WEST SUSSEX COUNTY COUNCIL CONSULTATION

TO:	Arun District Council FAO: David Spring
FROM:	WSSC - Highways Authority
DATE:	10th January 2020
LOCATION:	Land at Phase 1A Oldlands Farm Shripney Road Bognor Regis PO22 9NN
SUBJECT:	BE/126/19/PL Erection of a discount convenience retail food store (Use Class A1) & parking, landscaping & other associated works.
DATE OF SITE VISIT:	8th January 2020
RECOMMENDATION:	Advice
S106 CONTRIBUTION TOTAL:	See comments in Sustainable Access contribution

PROPOSED SITE PLAN

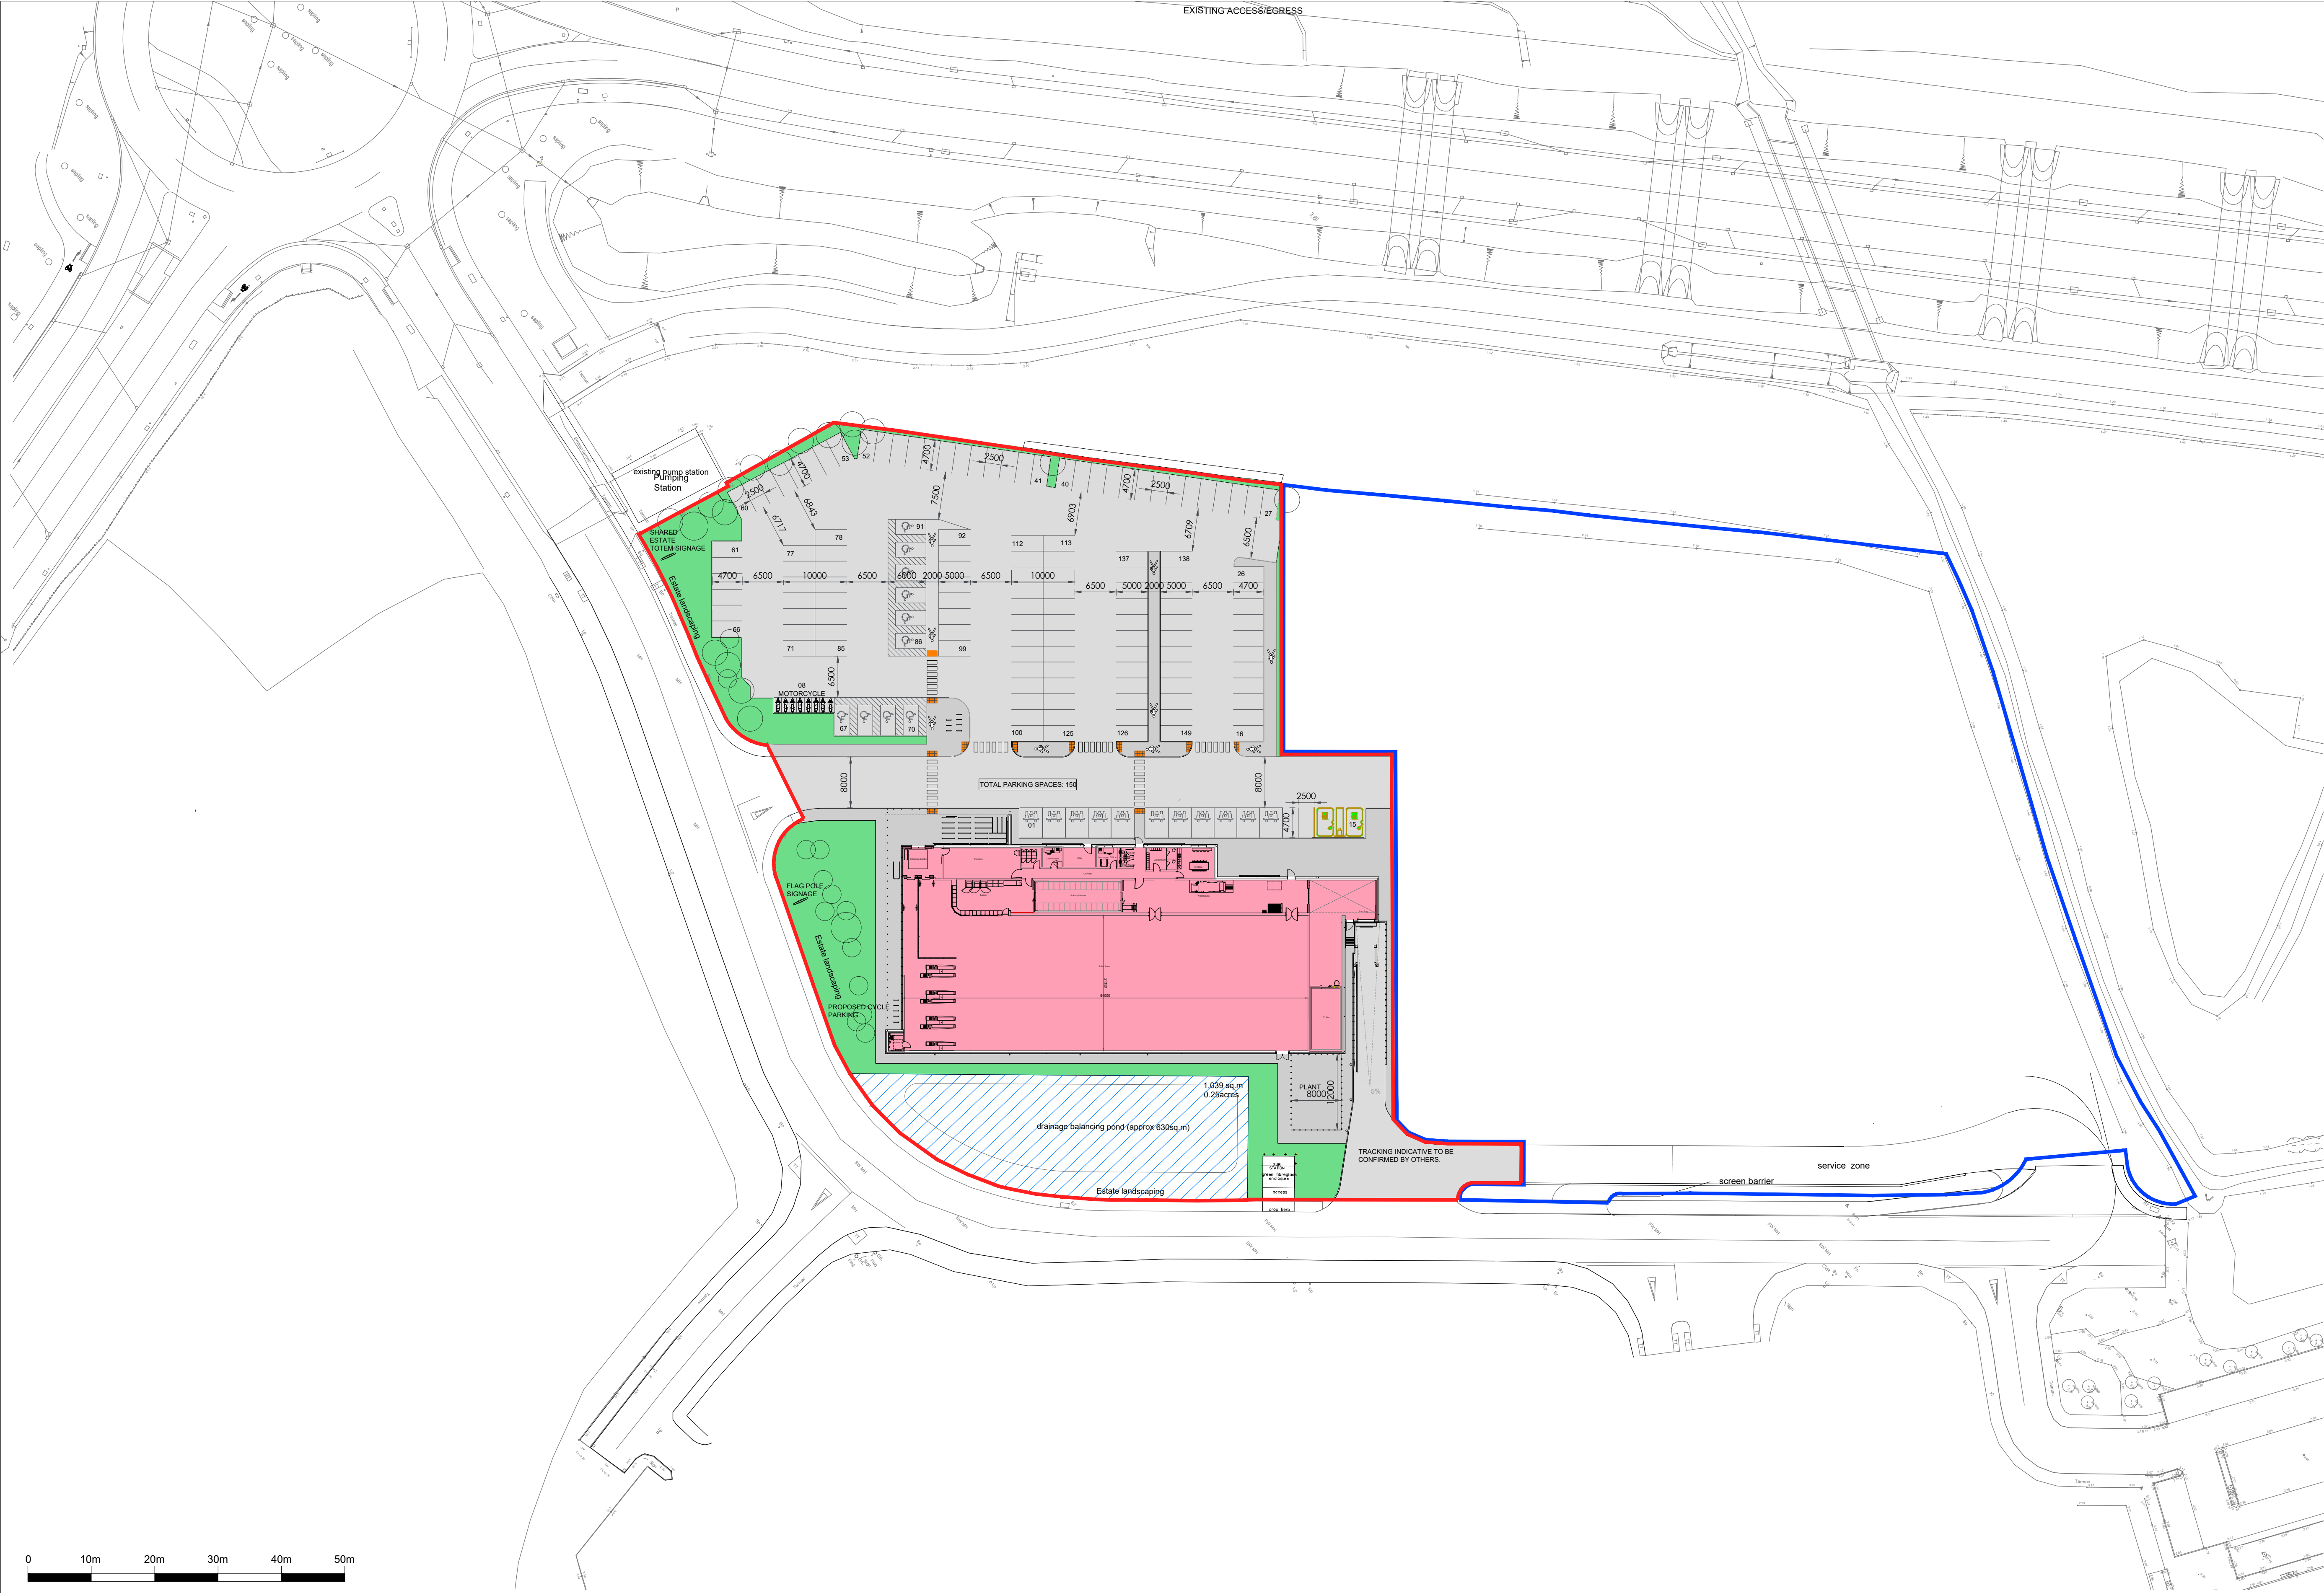
The application will have a total of 149 car parking spaces. These include 2 EV spaces. Based on the LHA's parameters of 1 space per 14m² the requirement would require 165 spaces. The LHA would be satisfied with the proposals consideration has been given to the flexible approach and linked trips to the development proposals. Parking spaces should have dimensions of 2.4 by 4.8 metres and 3.3 by 4.8 metres for disabled parking spaces.

In terms of parking the site will provide 24 customer cycle parking spaces which will be provided in 12 Sheffield stands. Parking for staff will be contained within the site.
